LDG- **313306-22**

APPENDIX 1: Response to KCC Report
(Refer to parks report in Appendix B of KCC's planning report for full details)
Issue 3

The Big Space Ltd

Public Lighting Layout

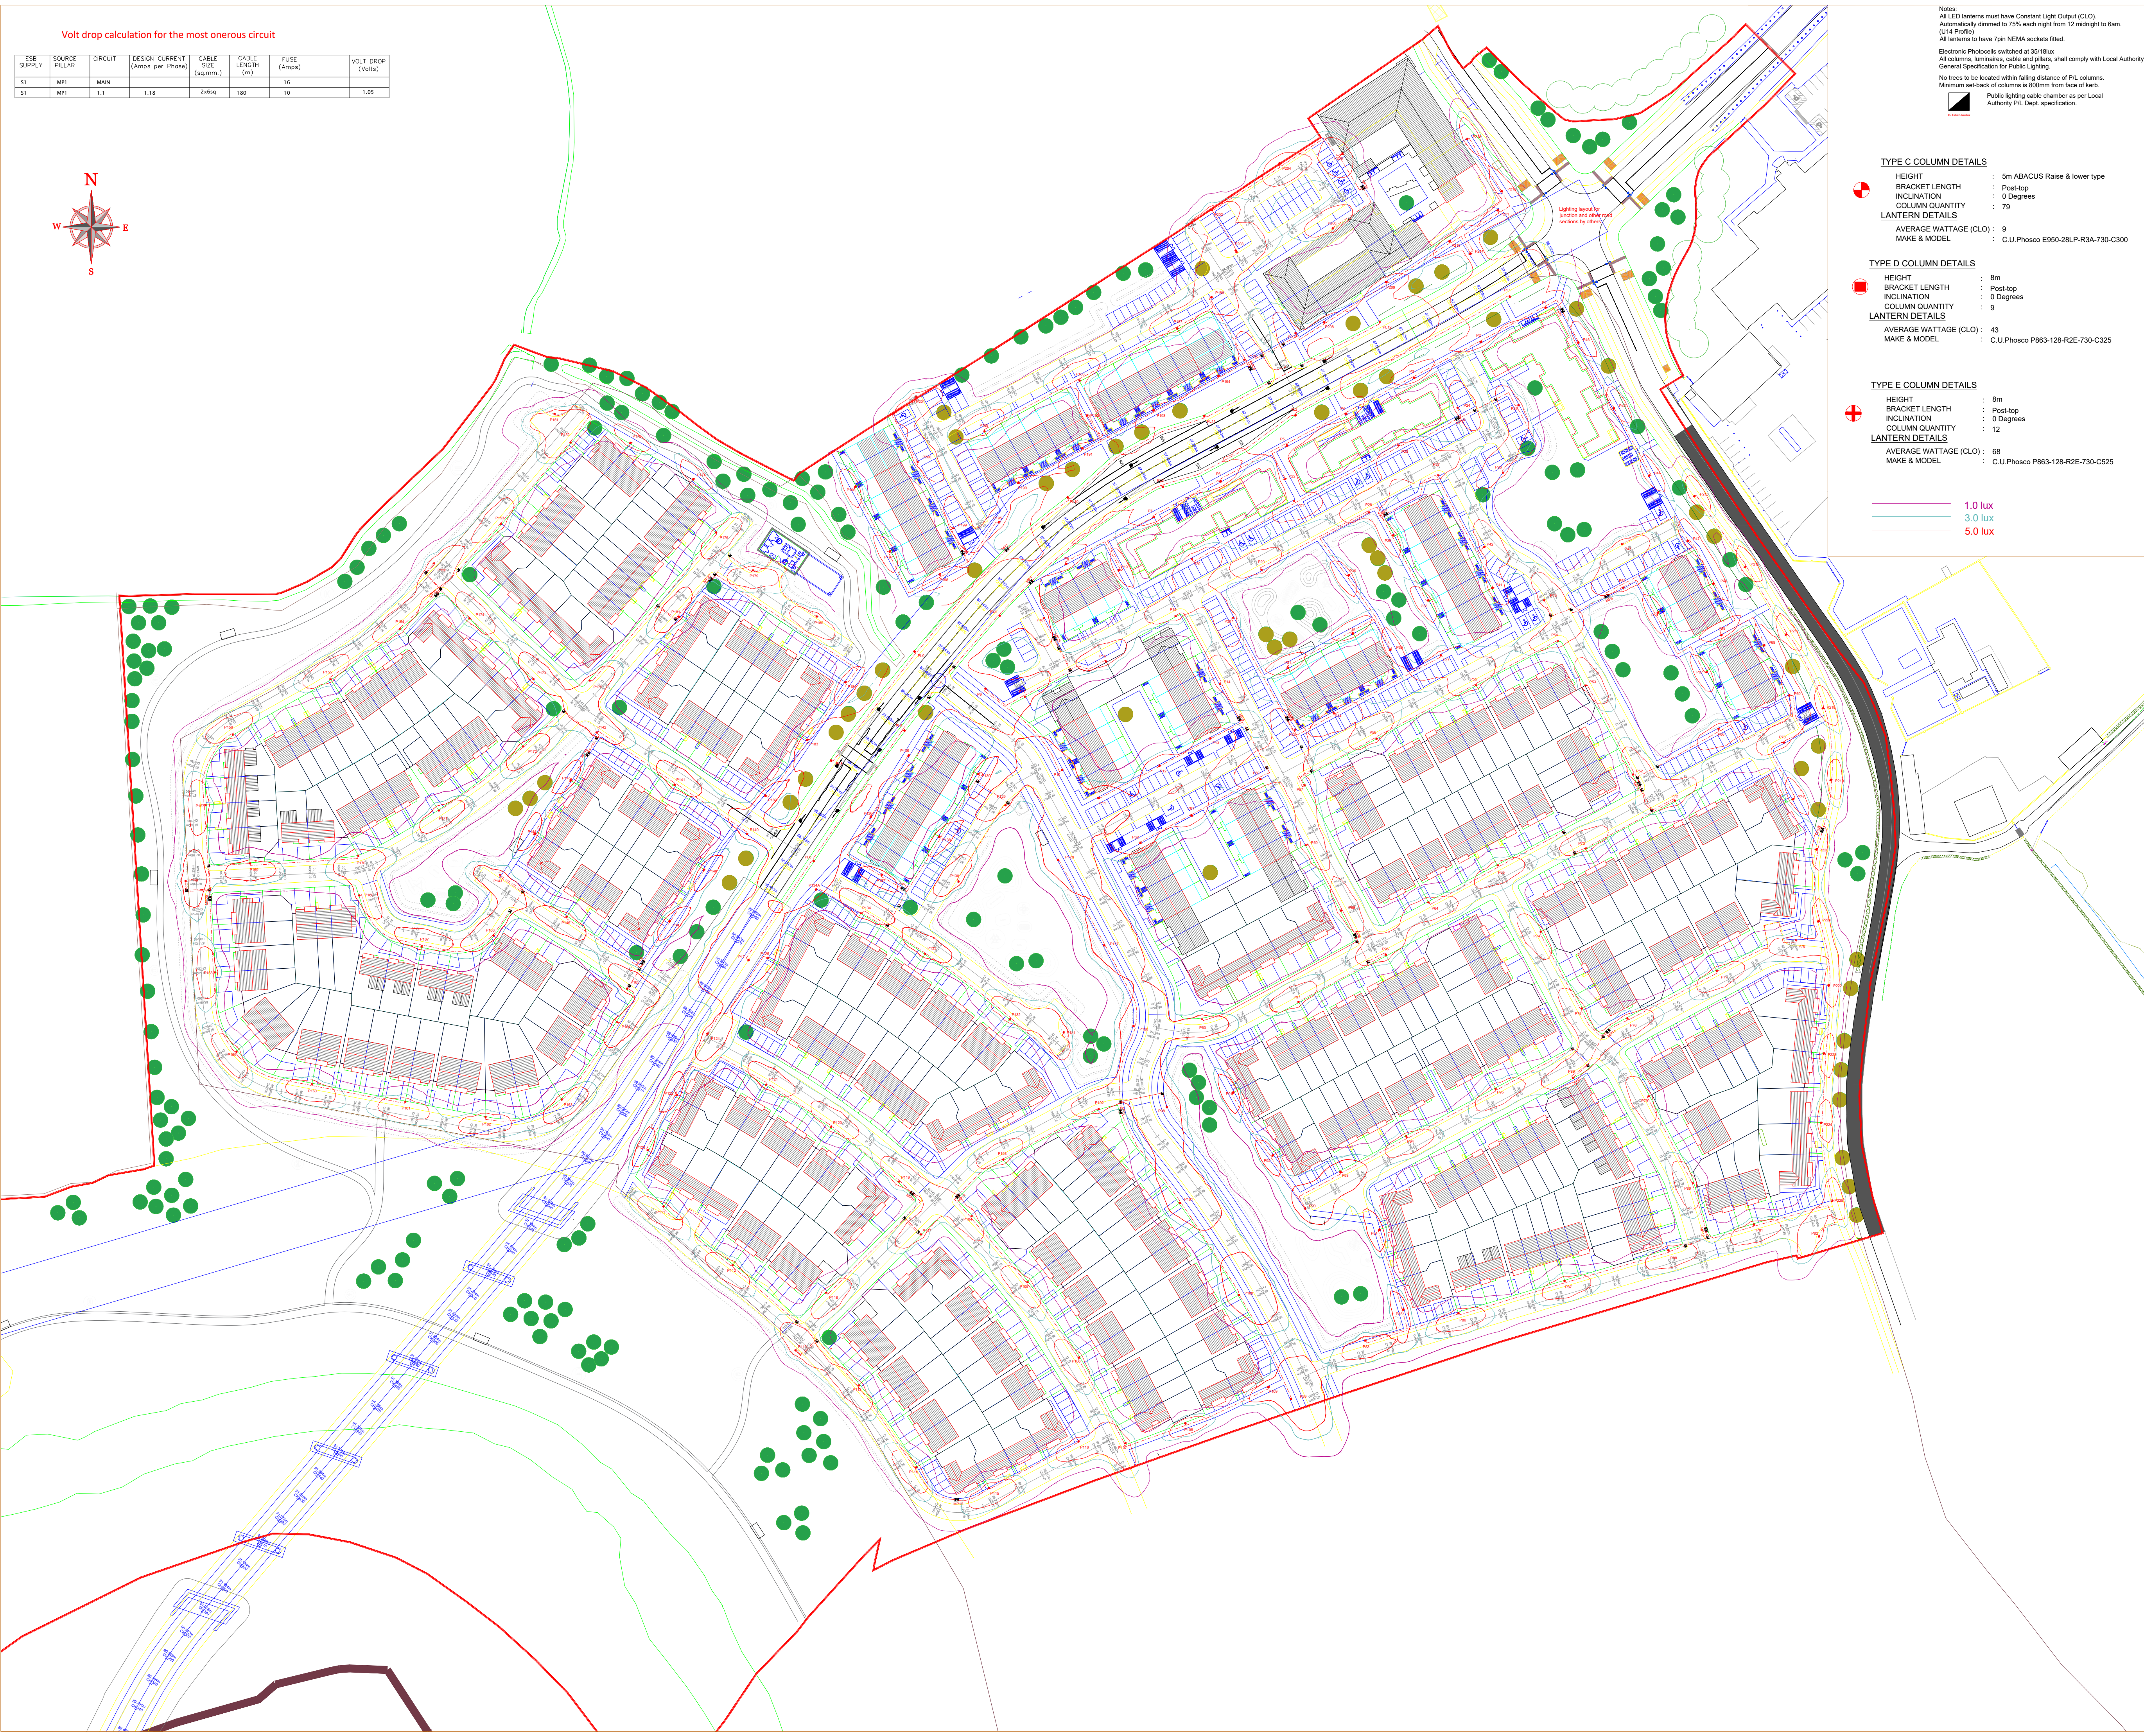
Applicant is requested to show sections drawings (north-south and east-west) through the proposed development to illustrate the existing and proposed finished topography	Refer to architects sections that identifies existing and proposed topography Refer to Sections G-G to L-L on TBS dwg 307
Landscape proposals to detail precisely which locations utilise such systems as 'root barriers'	Refer to TBS dwg 308 for proposed locations of same
Landscape proposals to detail the surface types and edges of all proposed footpaths and cycle tracks.	Refer to engineers dwgs for details of same
Materials and finishes of all proposed seating to be submitted.	Refer to Landscape Development Report, Section 2.2 for detail of Omos bench or similar approved
Landscape design shall ensure that the trees are planted at sufficient distance from any public lighting to avoid future conflict.	Refer to TBS dwg 300 for confirmation of same

DETAIL SHEET 3: RIVER PARK & WESTERN PARK PLAN

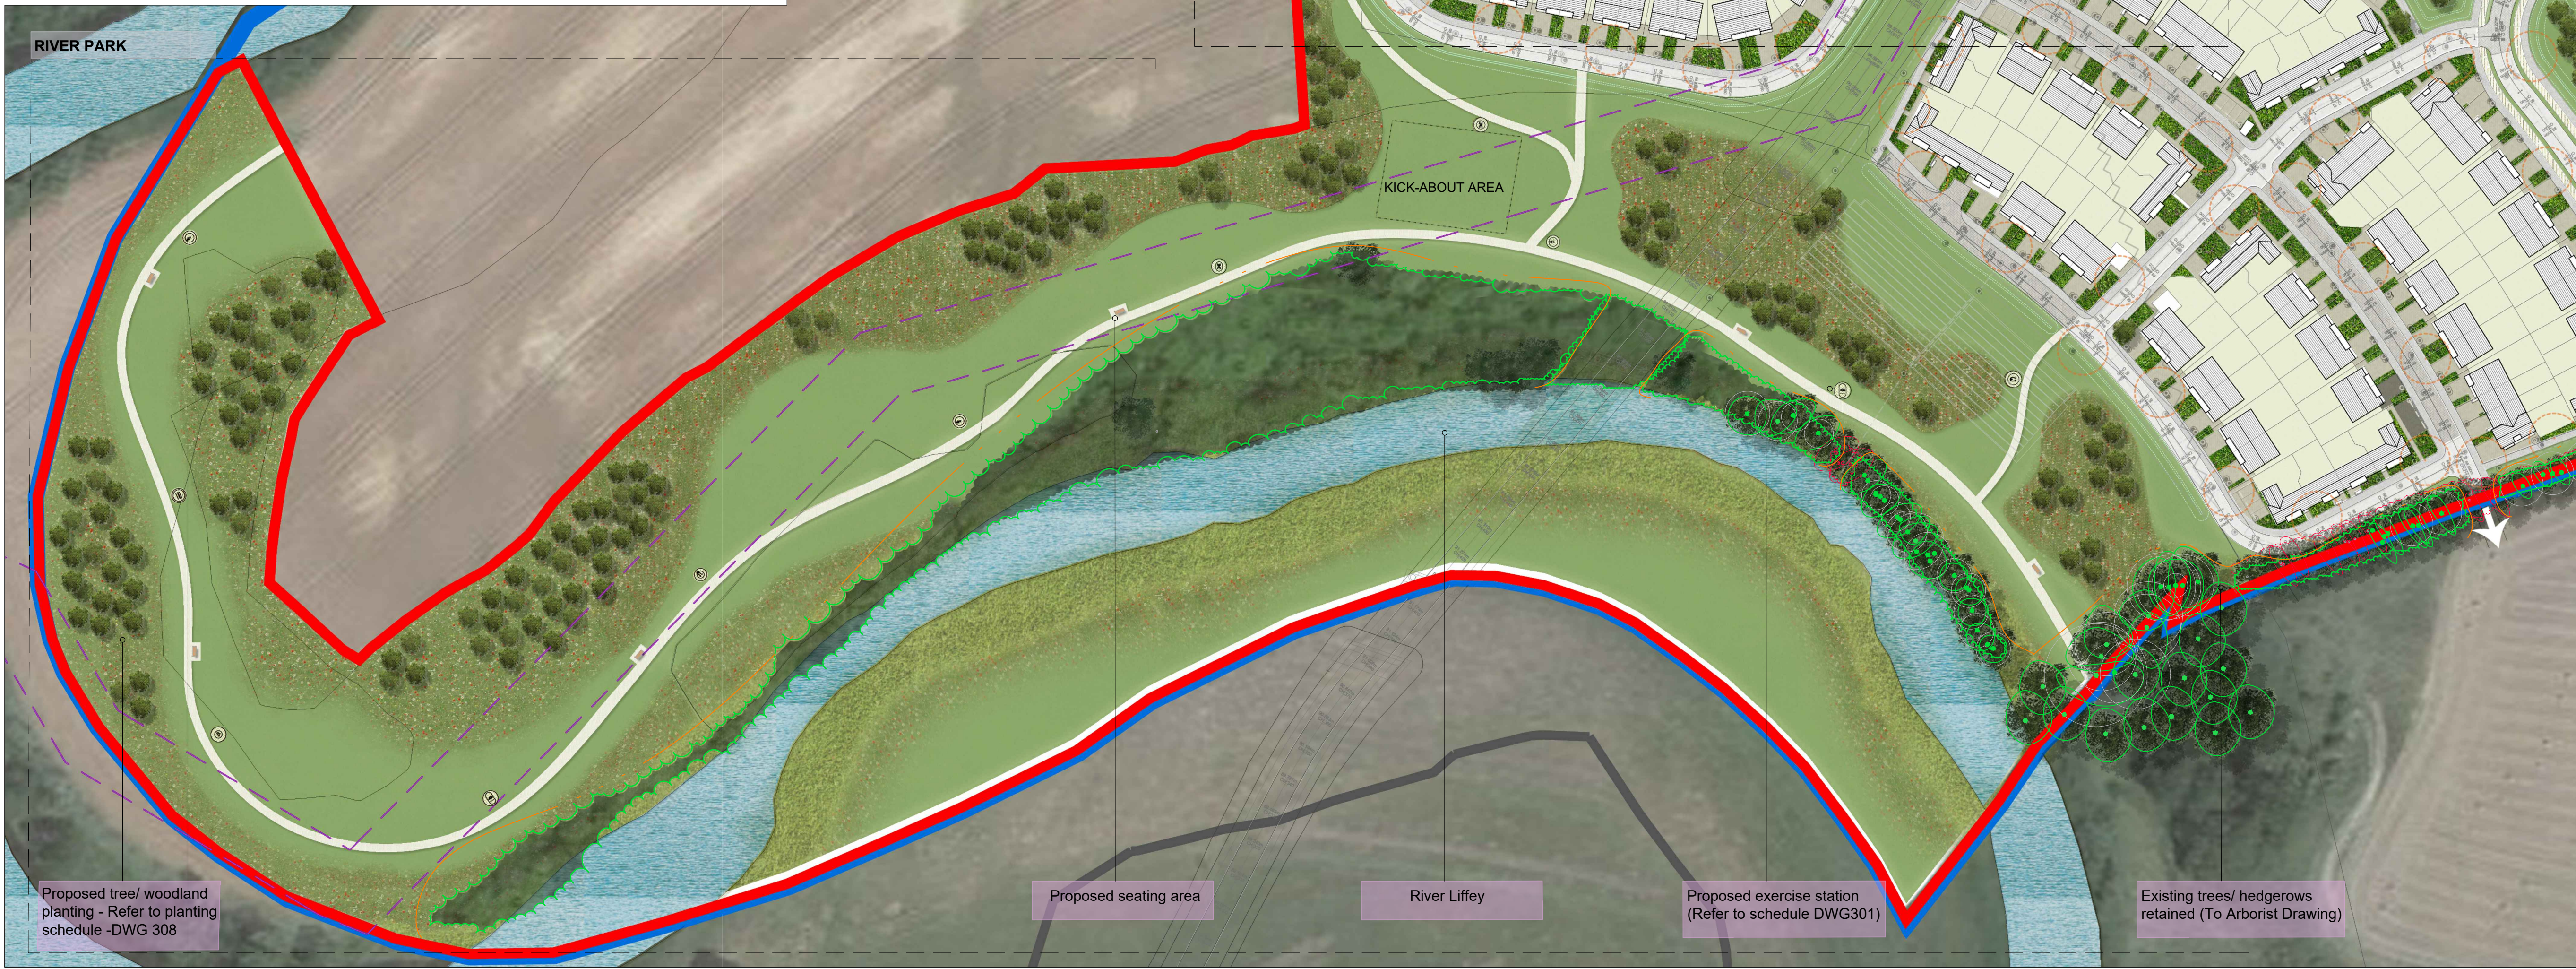
It is also a requirement of the Parks Section that 'flooding considerations' be central to the design proposals for this area.	The landscape proposals for the Liffey Linear Park have been fully informed by flooding considerations in consultation with JBA Consulting Engineers who prepared the SSFRA. Refer to engineers dwgs for SW drainage proposals
Detail Design Item	
All play areas shall be designed to provide a variety of natural play opportunities (i.e.natural spaces) and provide for universal access. Any proposed structures or items with swings, nets, ropes, and movable parts should be omitted (report includes a list of items to be revised).	Refer to TBS dwgs 300,301 &302 and Landscape Design Strategy, section 2.4 for information on natural play provision

drg. PROPOSED SITE SECTIONS 2

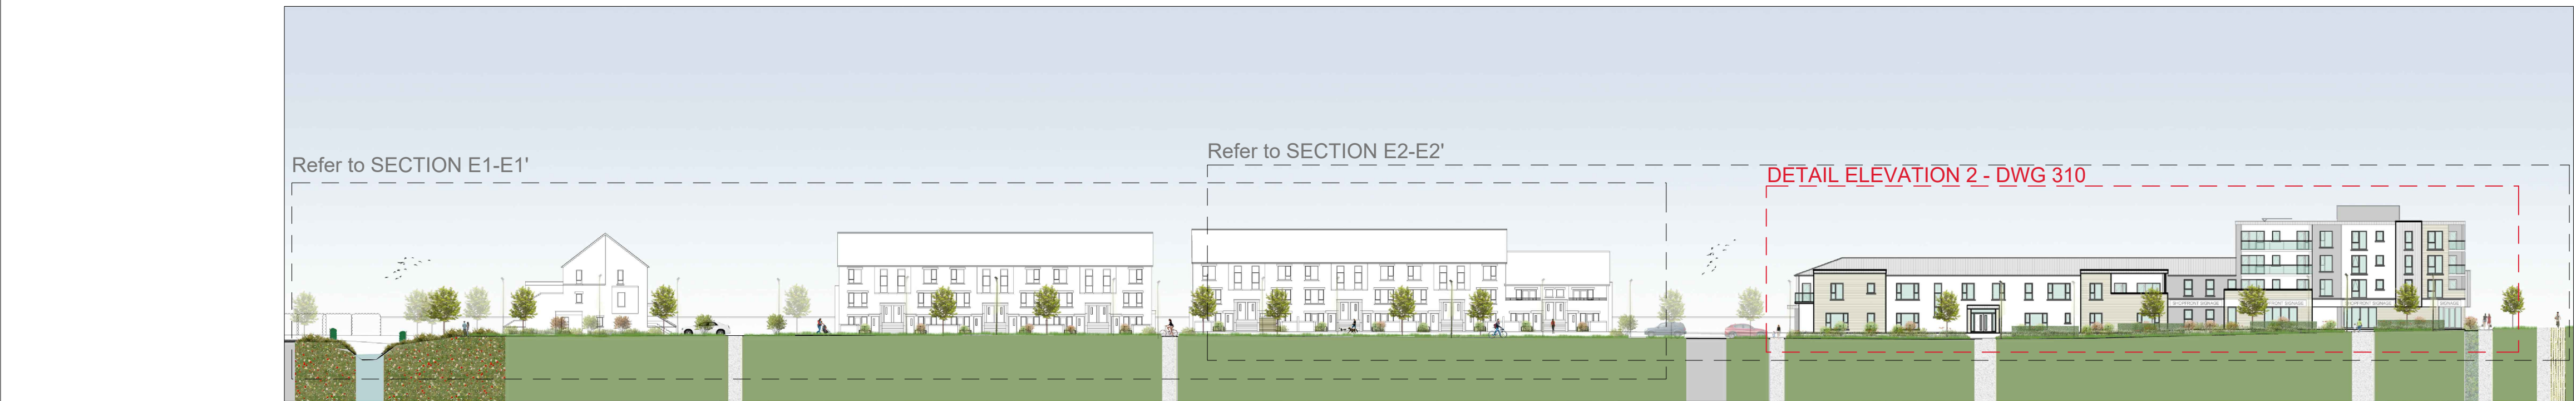
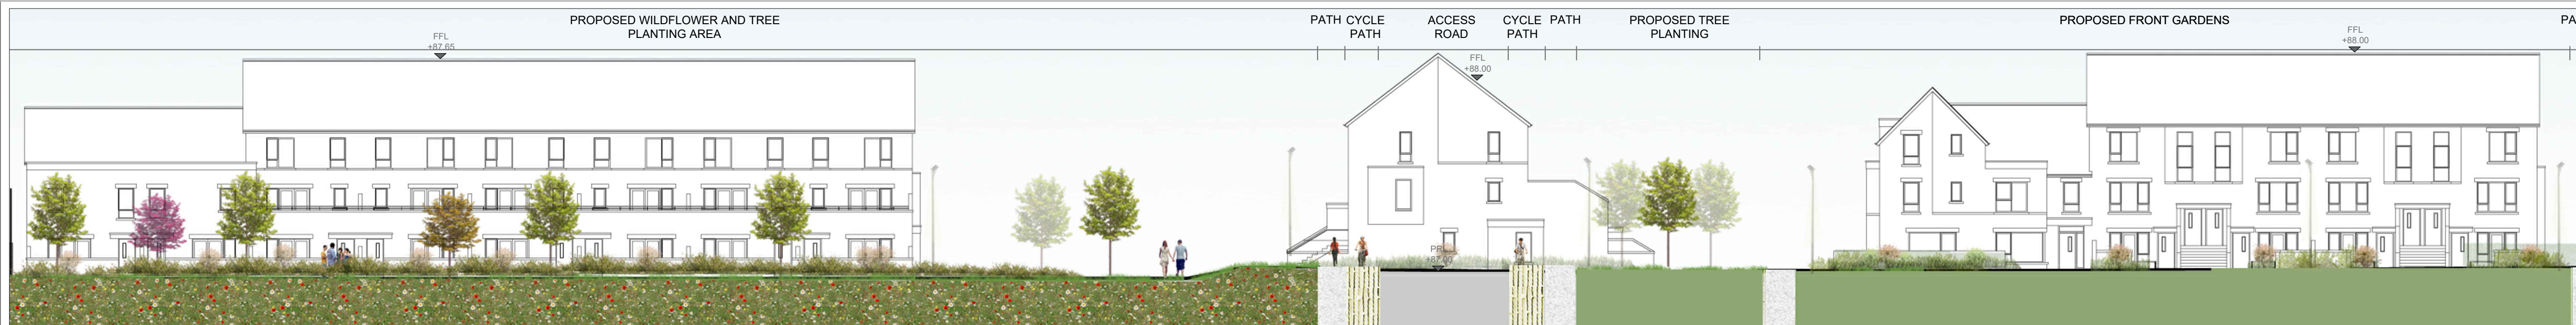
Requirement	Response
A comprehensive Landscape Design Rationale & Landscape Proposal prepared by a suitable and qualified Landscape Architect. The following shall be included: <ul style="list-style-type: none"> Scaled Landscape Masterplan with cross-sections (where appropriate) showing the general layout and hard and soft landscape treatment of all external areas/spaces, boundaries, structures, and features. Details of Hard Landscape Design Details of Soft Landscape Design Clearly outlined Landscape Plan 	Refer to TBS dwgs 300-311 and Landscape Design Strategy
Landscape Plan to contain sufficient section drawings through all open space areas of the proposed development and including the following: <ul style="list-style-type: none"> 'Linear River Park' & bridge adjacent to the River Liffey along the southern boundary. Existing watercourse near Wellesley Manor in the north west of the proposed development. 	Refer to TBS dwgs 300-3011 and Landscape Design Strategy inc.: Section A-A' & B-B' in dwg 302 Section C_C' & D-D' in dwg 304 Section E_E' & F-F' in dwg 305 Section G-G, H-H, I-I, J-J', K-K, L-L' in dwg 307
